Tahmoor South Project (SSD 8445): Second Project Amendment Report August 2020

I refer to the Department of Planning, Industry and Environment's (DPIE) correspondence dated 4 August 2020 inviting the Resources Regulator to comment on the Tahmoor South Project (SSD 8445) Second Project Amendment Report dated August 2020 (Amendment Report). A response from both the Mining Act Inspectorate (MAI) and Mine Safety Inspectorate (MSI) within the Resources Regulator is outlined below.

# Current approved REA Final Landform (under refinement)

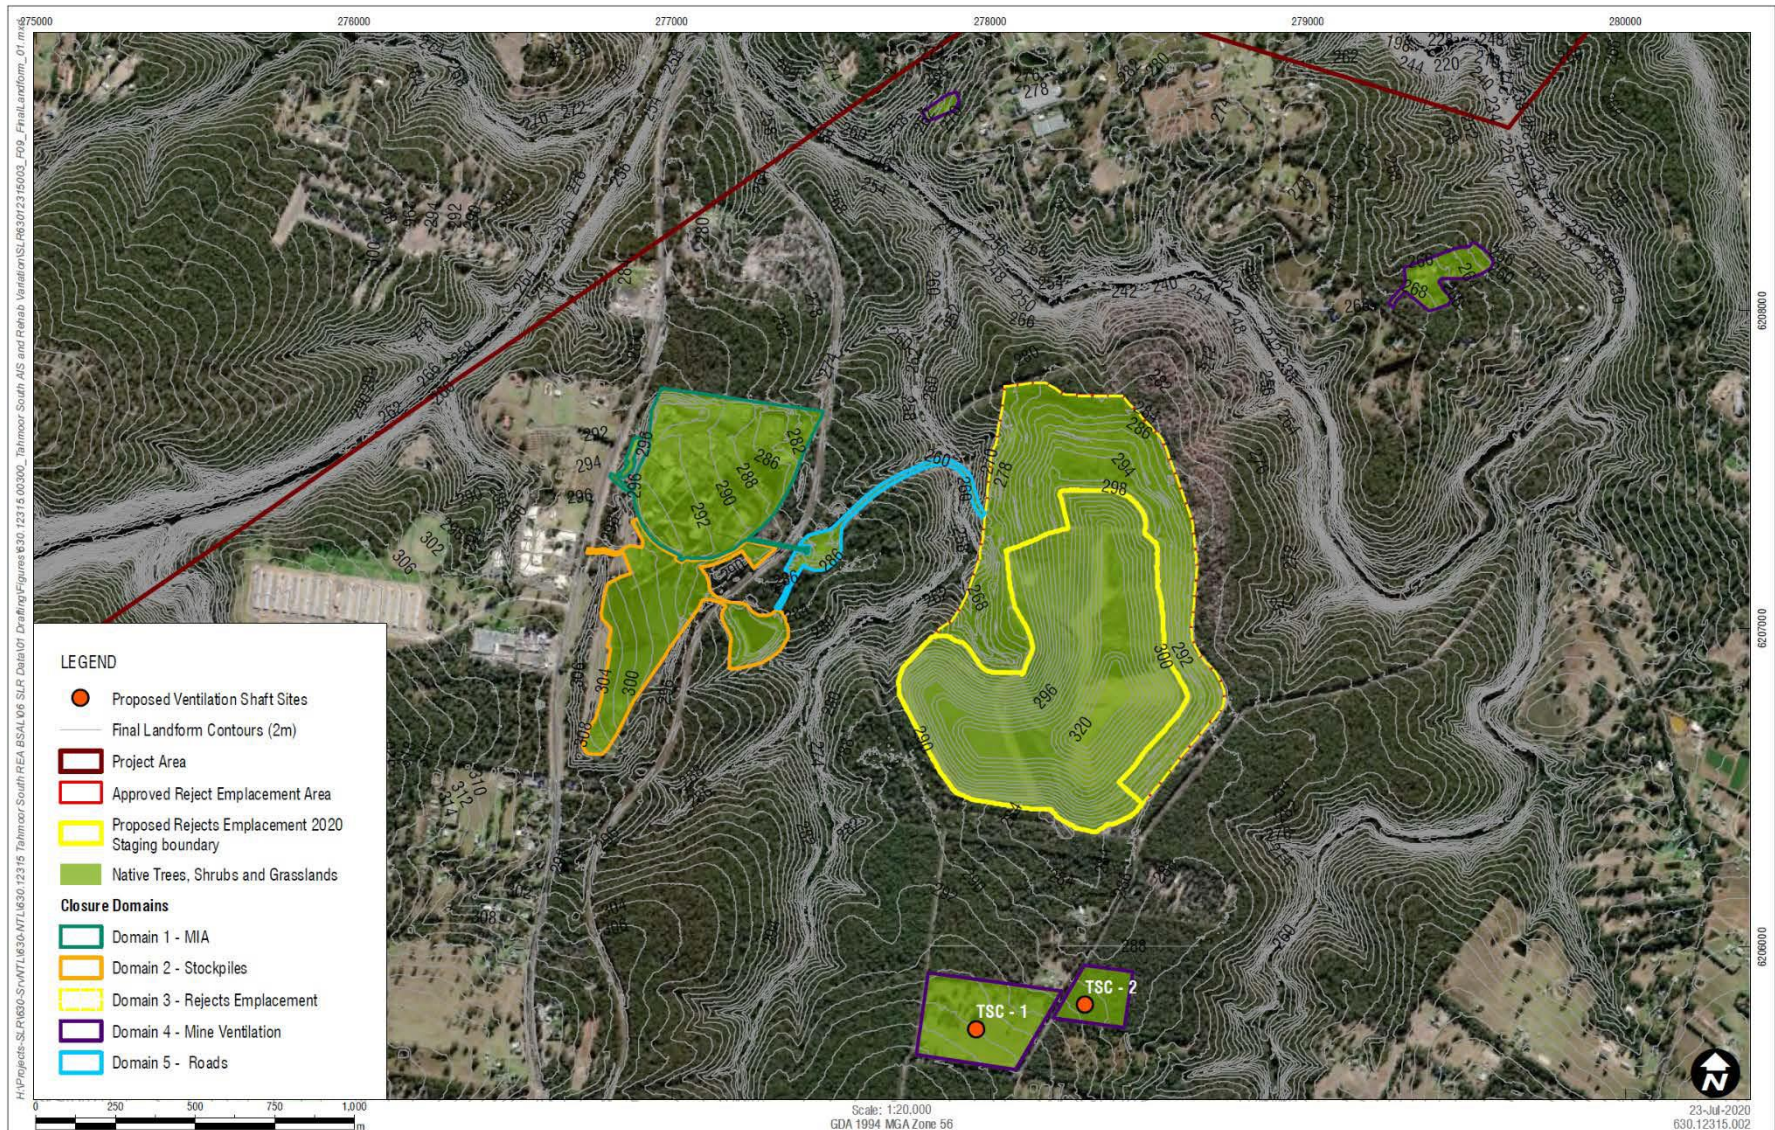
- Further information on the design of the surface water drainage network on the revised final landform and how runoff will be conveyed off a steeper areas without causing issues relating to erosion, exposure of rejects material in the long term and potential downstream sedimentation. Noting that the Regulator has previously issued statutory directions to Tahmoor to address erosion issues on the existing REA.

- It is noted that the area where the REA is to be increased in height by 10 metres will overlay existing rehabilitation that has been established by more modern revegetation practices. Given the potential risks of increasing the height of the emplacement area as detailed above, further options should be explored in regards to the emplacement of reject material to the northern part of the existing REA where the standard of rehabilitation is more commensurate with earlier revegetation practices. Emplacement activities in this area may present an opportunity to improve the standard of the existing rehabilitation in the northern area of the REA.

- There is a lack of information in the Rehabilitation Strategy in regards to the characterisation of reject material to justify the associated capping design that will be required to sustain the rehabilitation outcome (native and grassland). Further information is required to address risks associated with potential spontaneous
